Your Ref	SSD-45576956
Our Ref	NCA/12/2022
Contact	Alex McDougall
Telephone	02 9806 5998
Email	amcdougall@cityofparramatta.nsw.gov.au

02/06/2025

# COUNCIL SUBMISSION TO REQUEST FOR ADVICE ON EIS – CMRI GENE TECHNOLOGIES BUILDING (SSD-45576956) AT 178 HAWKESBURY ROAD, WESTMEAD NSW 2145

Figure 2: Updated Car Park Layout

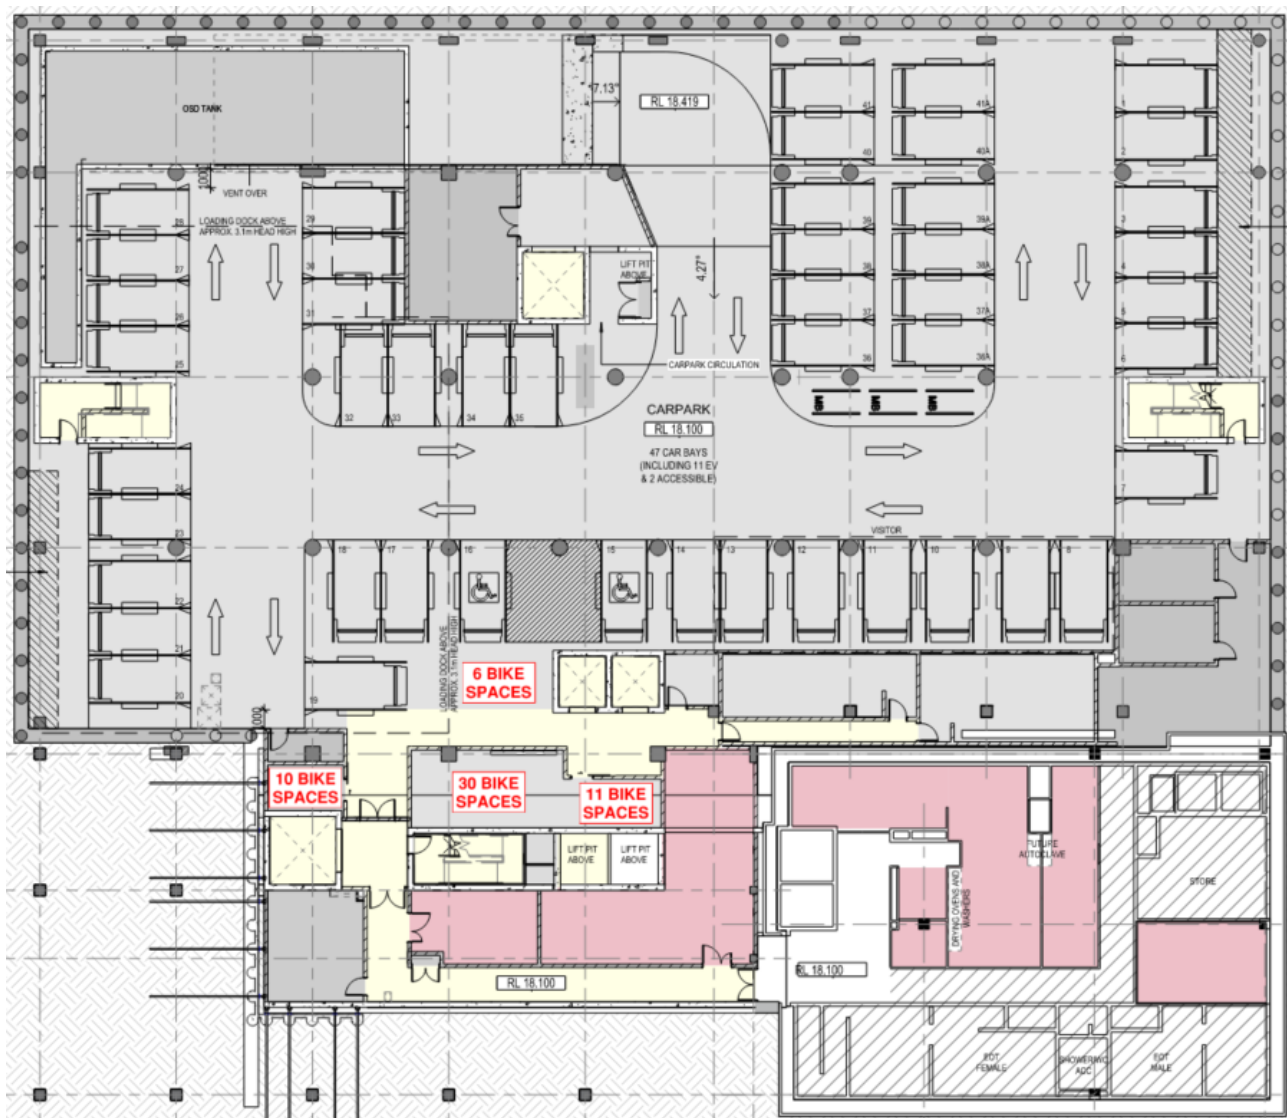
• The blind aisle extension next to parking spaces No. 1 and 47 does not comply with the requirements of AS 2890.1 which requires at least 1m to be provided for access to and from the spaces. Further, the column next to space no. 47 encroaches the design

envelope as per figure 5.2 of AS 2890.1. However, it is noted that the width of parking spaces is 2.5m whereas staff parking can be reduced to 2.4m. Accordingly, the plans should be amended to reduce the width of spaces No. 1, 45, 46, and 47 to 2.4m to allow for at least a 1m blind aisle extension. Similarly, it is noted that columns are obstructing the design envelope for the parking spaces Nos: 6, 26, 31 and 34 which will need to be addressed. Meeting these requirements should not impact any structural elements of the car park and can be conditioned.

- a. A minimum blind aisle extension of 1m is to be provided next to parking spaces No. 1 and No. 47. The width of the parking spaces can be reduced to 2.4m to achieve this noting that this is a staff car park.

- b. The location of the columns are to comply with figure 5.2 of AS 2890.1 and not encroach the design envelope. In this regard, adjustments are required for parking space nos. 6, 26, 31, 34 and 47

Figure 3: Pedestrian Access Route

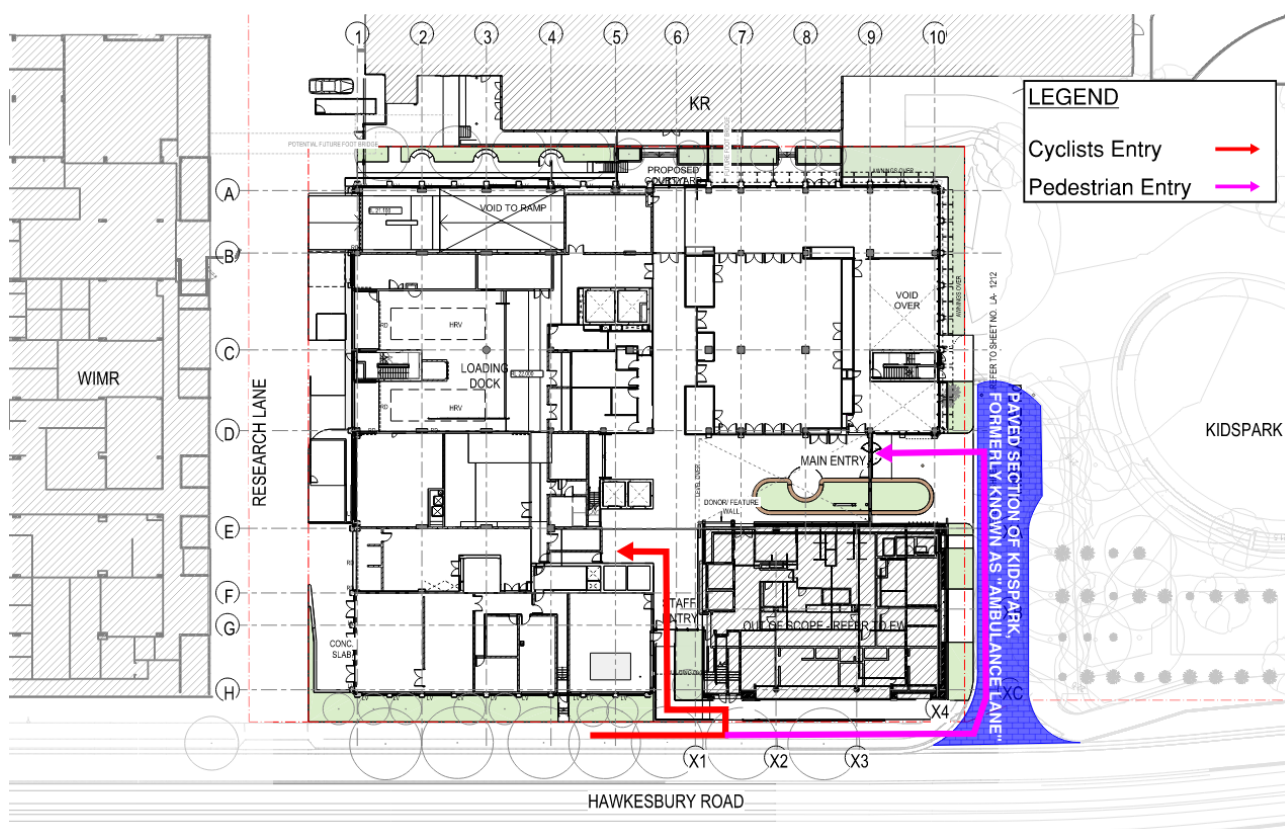
It is not clear how the building and its entrances integrate with the wider health precinct. For example, the report talks about pedestrian access via Ambulance Lane, but it is not clear what Ambulance Lane looks like from the report. Similarly, it is expected that cyclists coming from the east will access via Research Lane, but it is not clear how cyclists from north, or from the Health precinct, access the site. There should be good active transport connectivity to the Health precinct.

Sheet Subject
SITEWORKS AND STORMWATER
PLAN - GROUND LEVEL

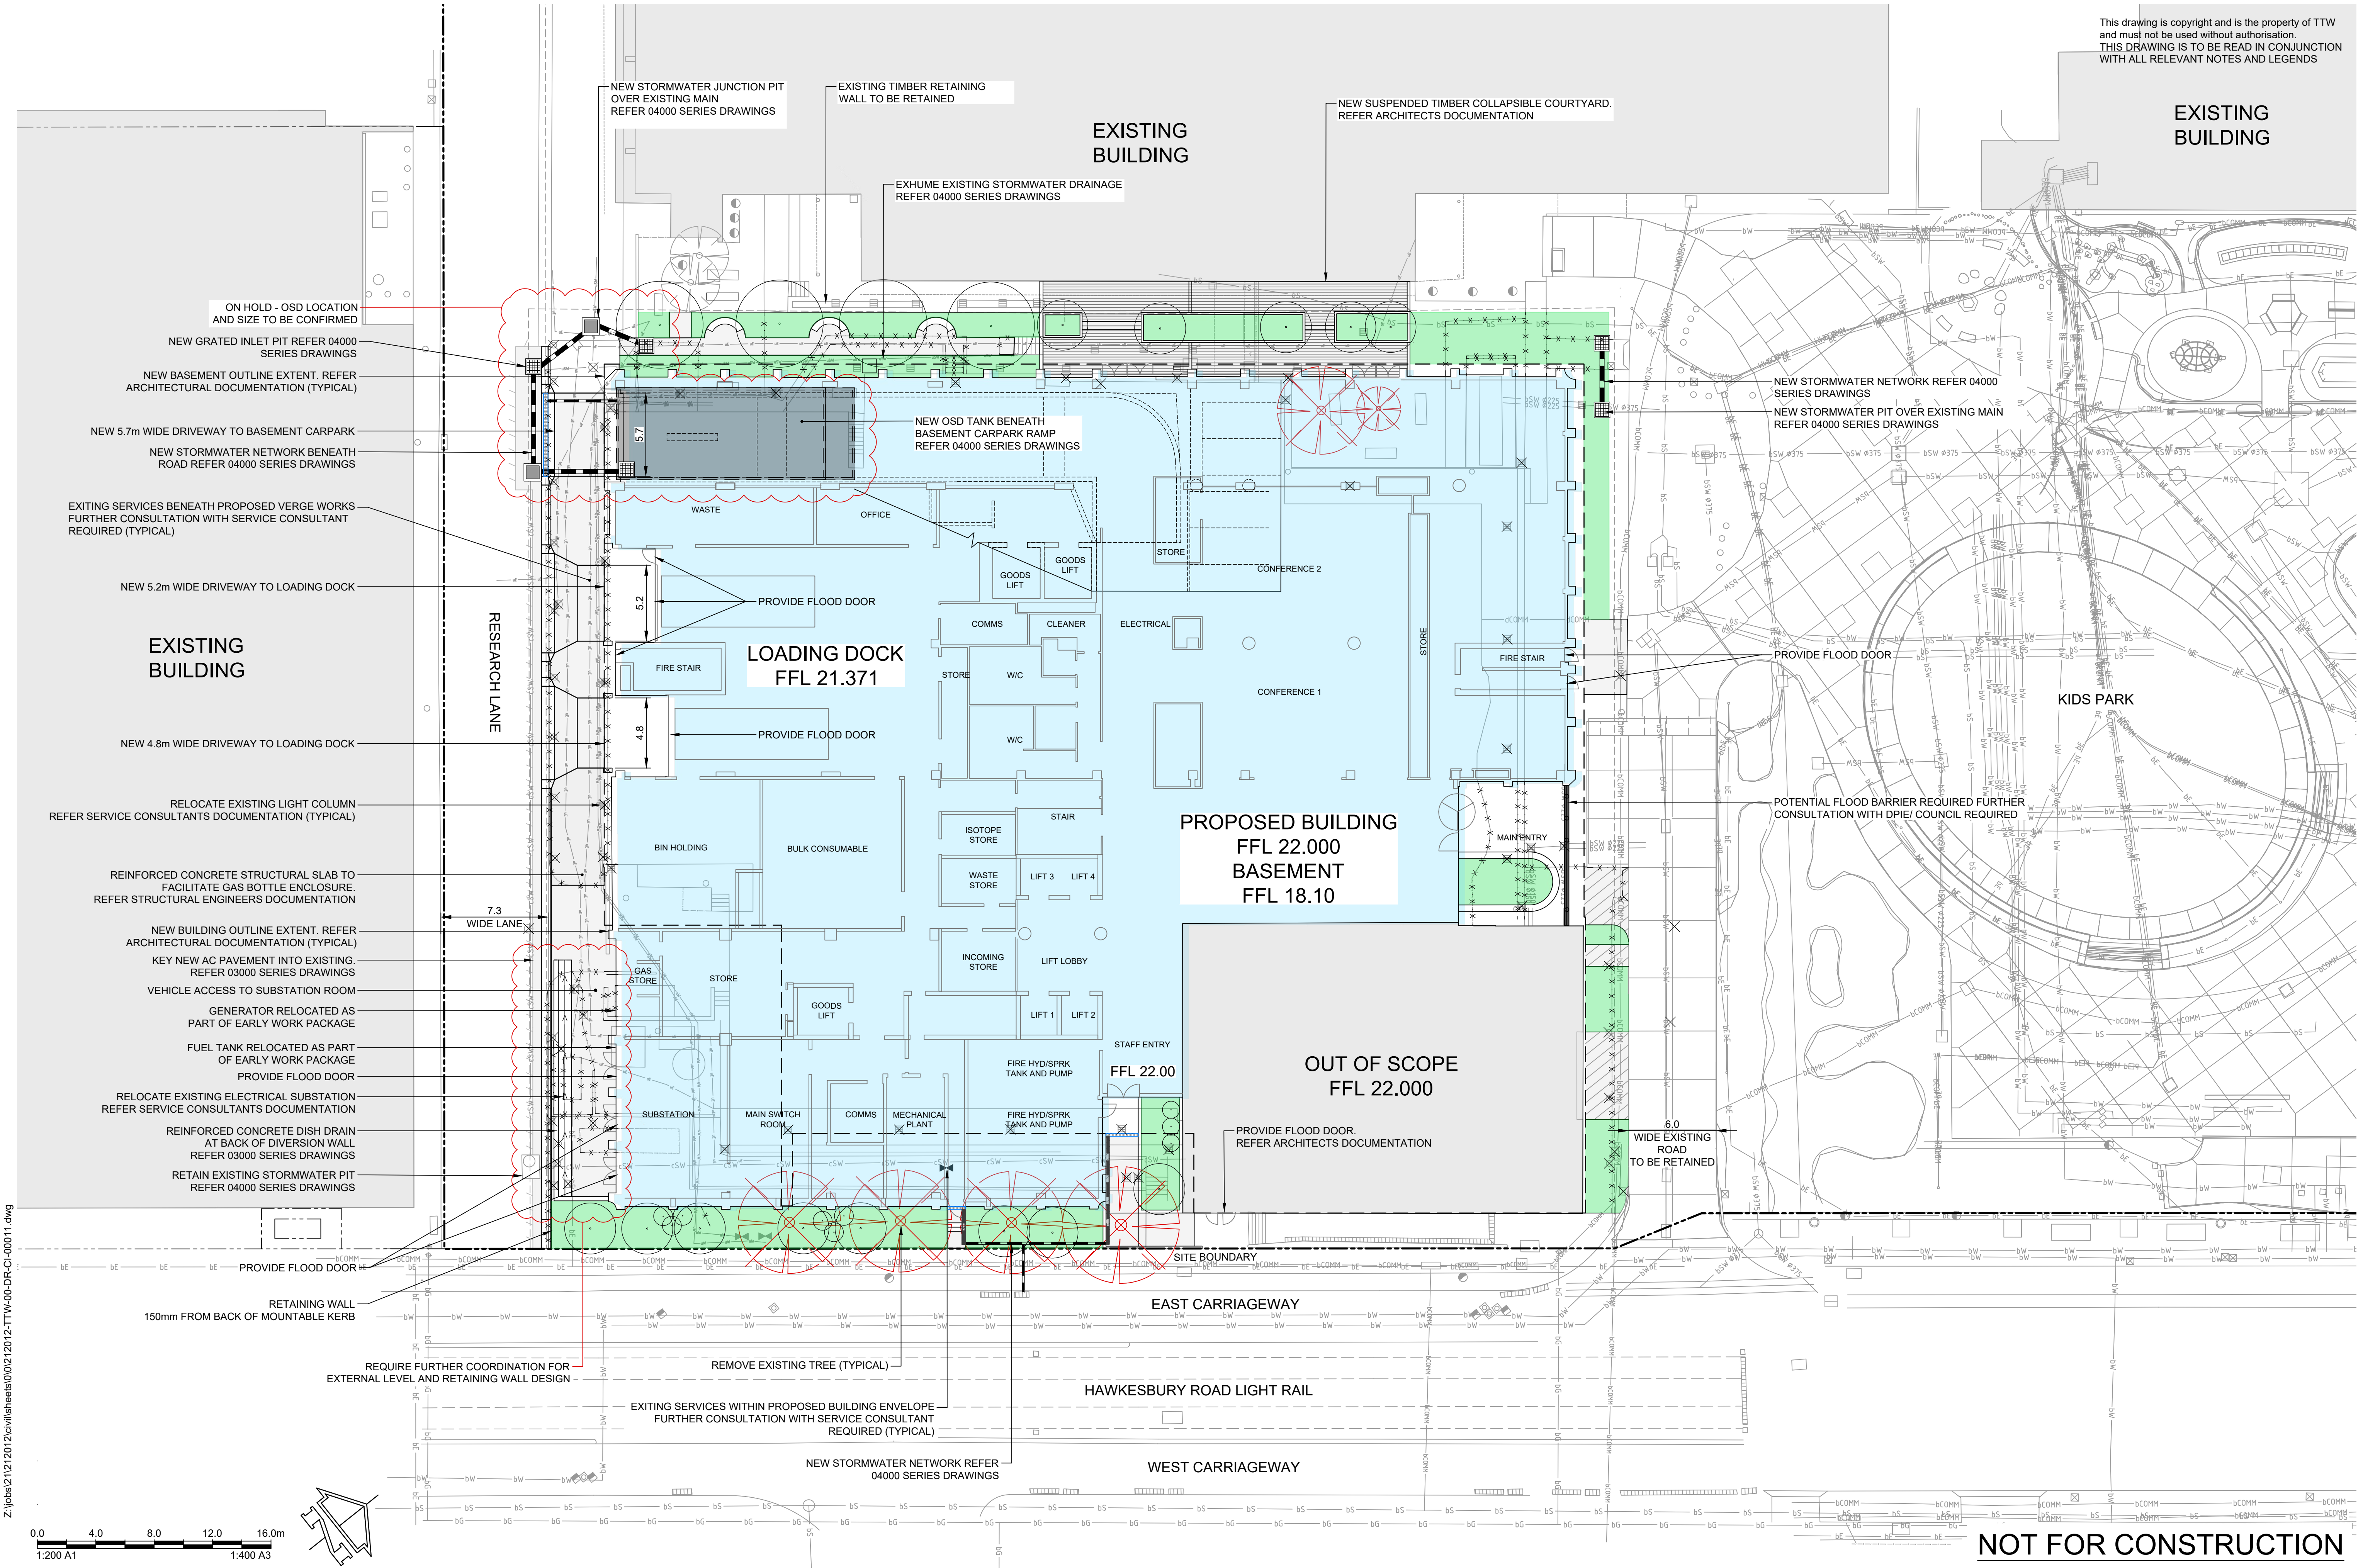
- The grass swale within the landscaped area along Hawkesbury Road presents a poor outcome for the main road frontage. It is recommended to replace it with underground drainage pipes (if not part of an overland flow flooding path).

Figure 2: Access Arrangement

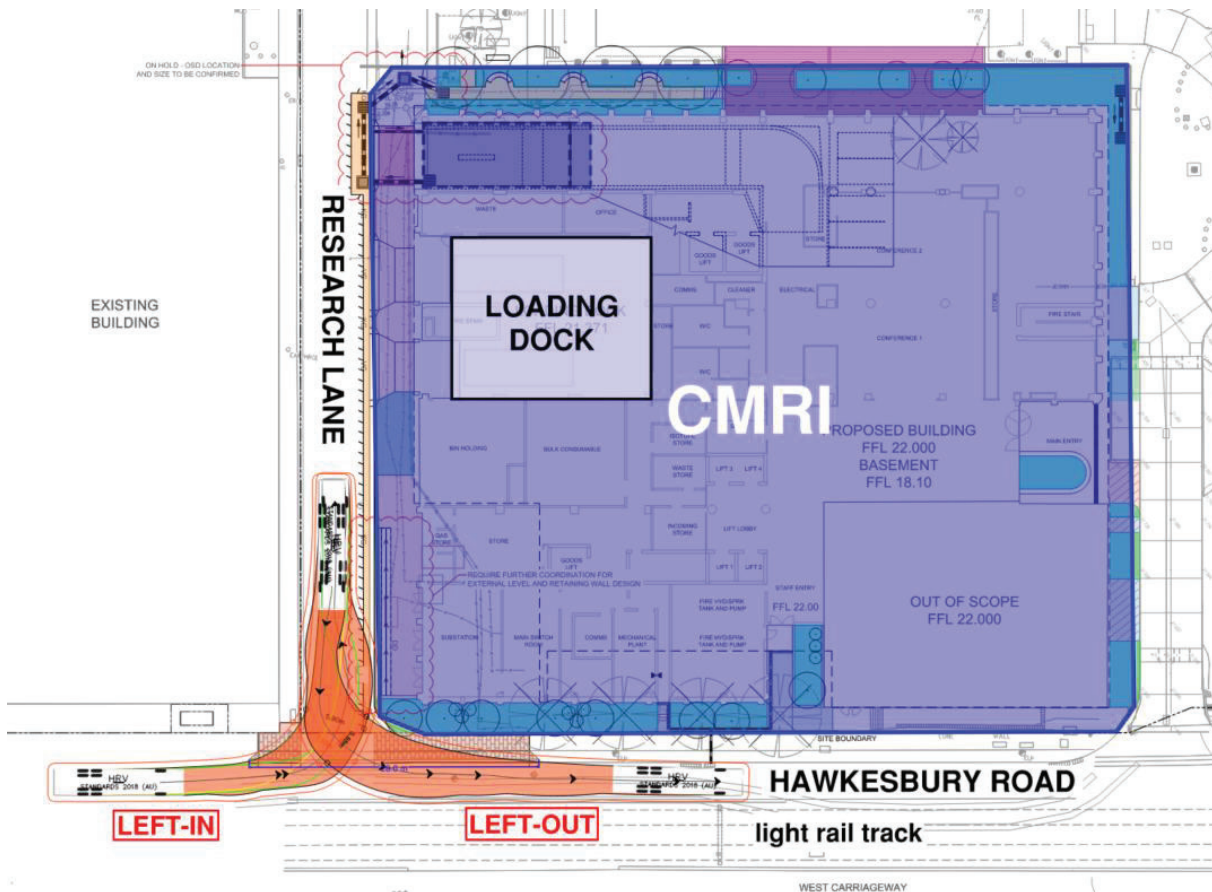
HRV swept paths appear to interfere with Parramatta Light Rail (PLR) tracks. Must be remedied or alternatives requires confirmation this is acceptable from Transport for NSW (TfNSW).
